HUNTERS POINT
LOTS 16 + 17
PROPOSED SEPTIC

PROPOSED SUBSURFACE WASTE DISPOSAL SYSTEM DETAIL SHEET

To: Freddie Stencil
Fax number:

Regarding: Hunters Point, Lots 16+17. (4 pages)

Lot 17 Hunters Point
81 Henry Rifle Lane
07-50016953

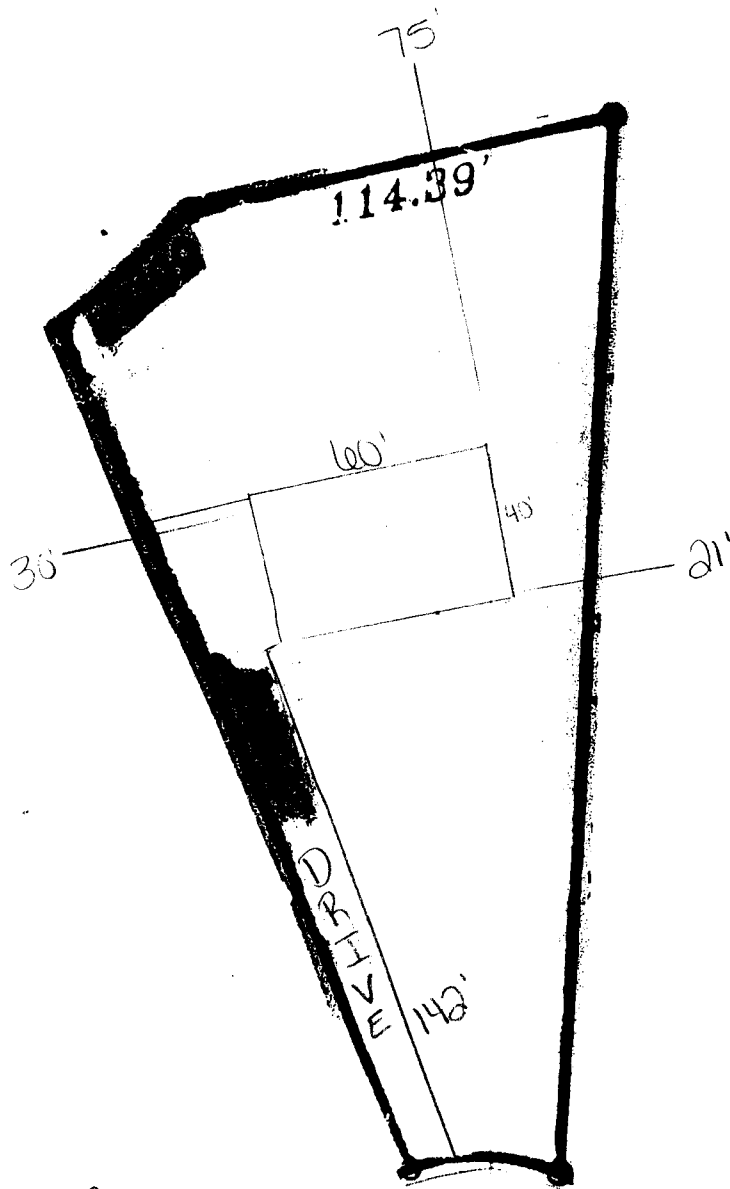
- ① LOT 16 SHOULD BE APPROVED AS YOU PREVIOUSLY SUBMITTED
- * ② LOT 17 NEEDS TO BE REVISED WITH A 142' HOUSE SETBACK. YOU WILL ALSO NEED TO REFLAT LOWER PROPERTY LINE (AS SHOWN) TO VERIFY LOCATION. IT MAY NEED TO BE SLIGHTLY ADJUSTED TO MAINTAIN 10 FT. PLEASE SUBMIT NEW PLOT TO HARN CO.
- ③ I HAVE MET OLIVER (HARNETT CO) ON SITE AND RECEIVED APPROVAL FOR THESE DESIGNS.
